Our Ref: R/257/13/

Town & Country Planning Act 1990 (as amended)
Town and Country Planning (Development Management Procedure) (England) Order 2010 (as amended)
Application for Full Planning Permission

Development Change of use from B1 (Business) to a dog day care centre & boarding facility (Sui Generis)
Location Unit 2, Phoenix Terrace Artex Avenue Rustington

Existing Ground Floor Plan 1:100

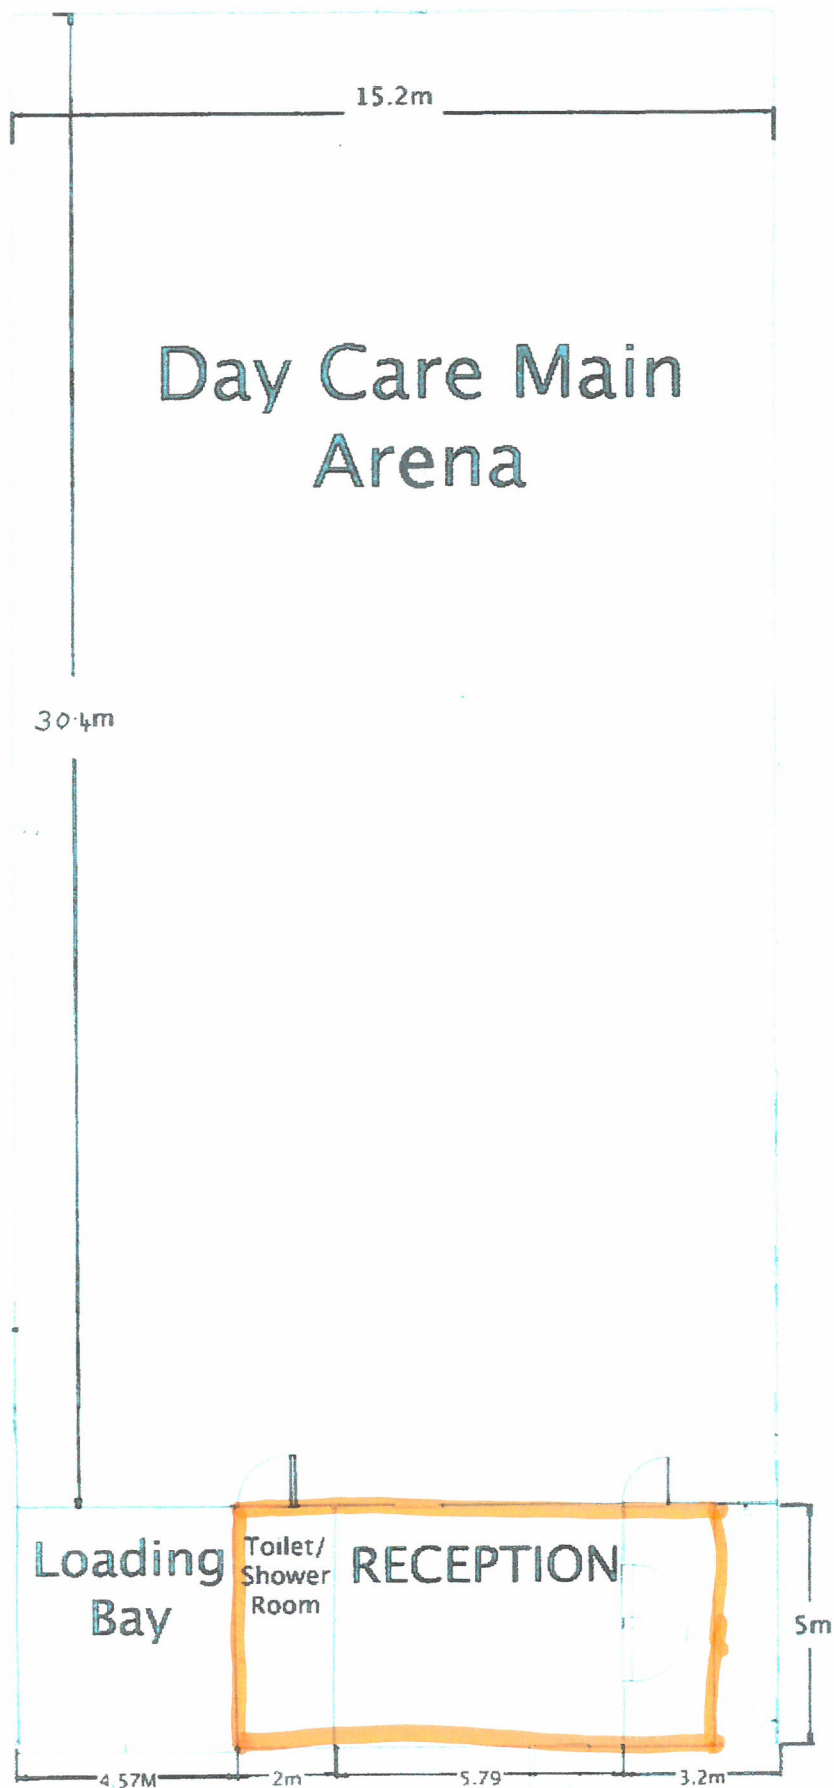
We require existing floor plans. To scale and labelled.

Unit 2 Phoenix Parade

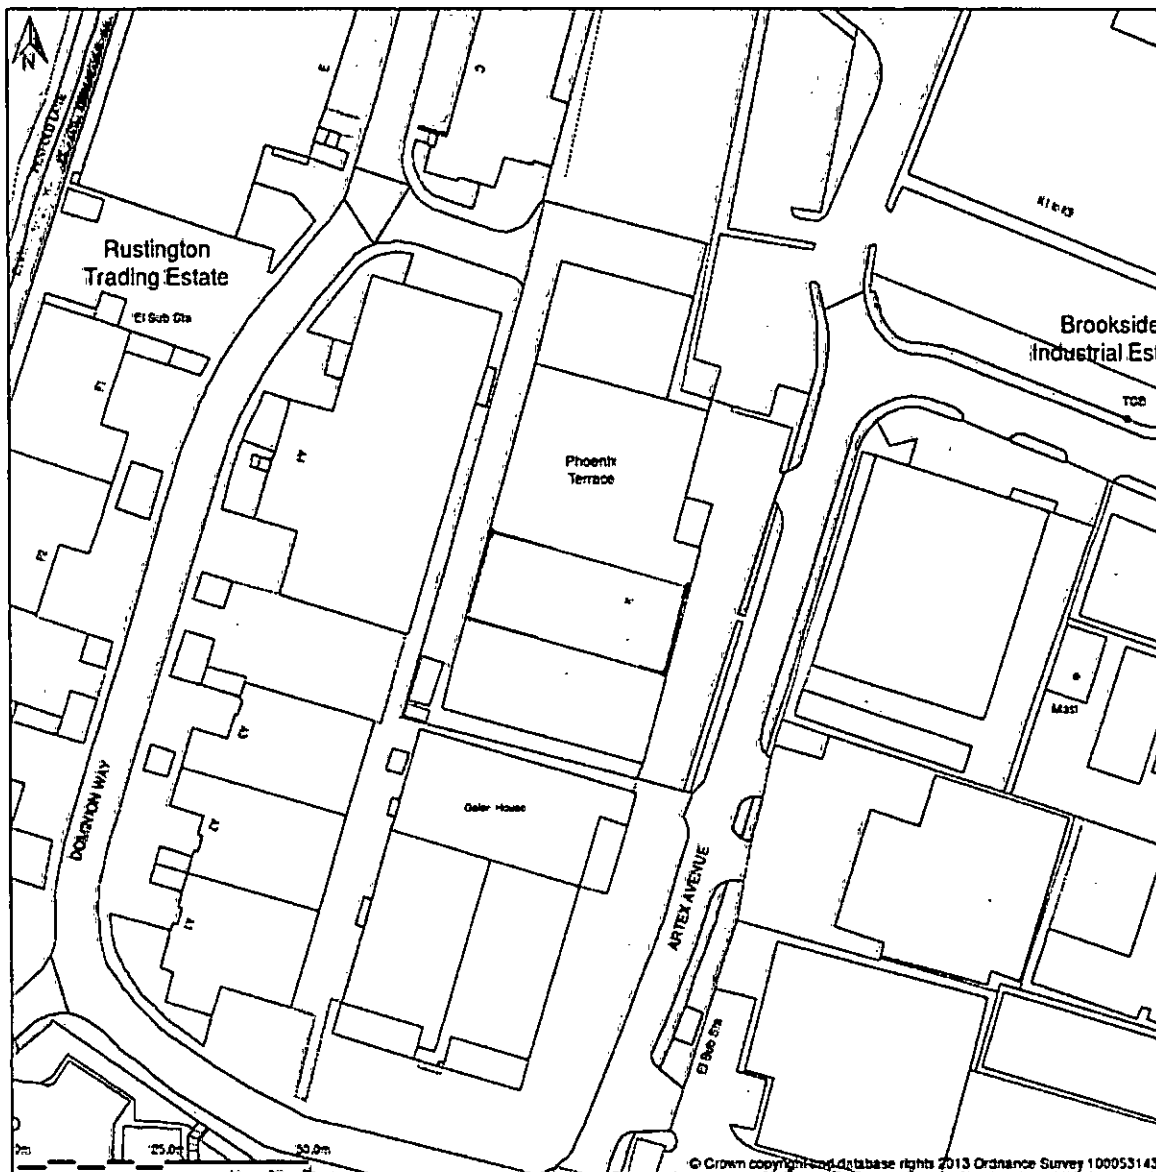
The location plan is incomplete. You need to red edge the site area (area that this application relates to only).

Please submit amended block plans to clearly show the building that this application relates too. I would suggest hatching the relevant building
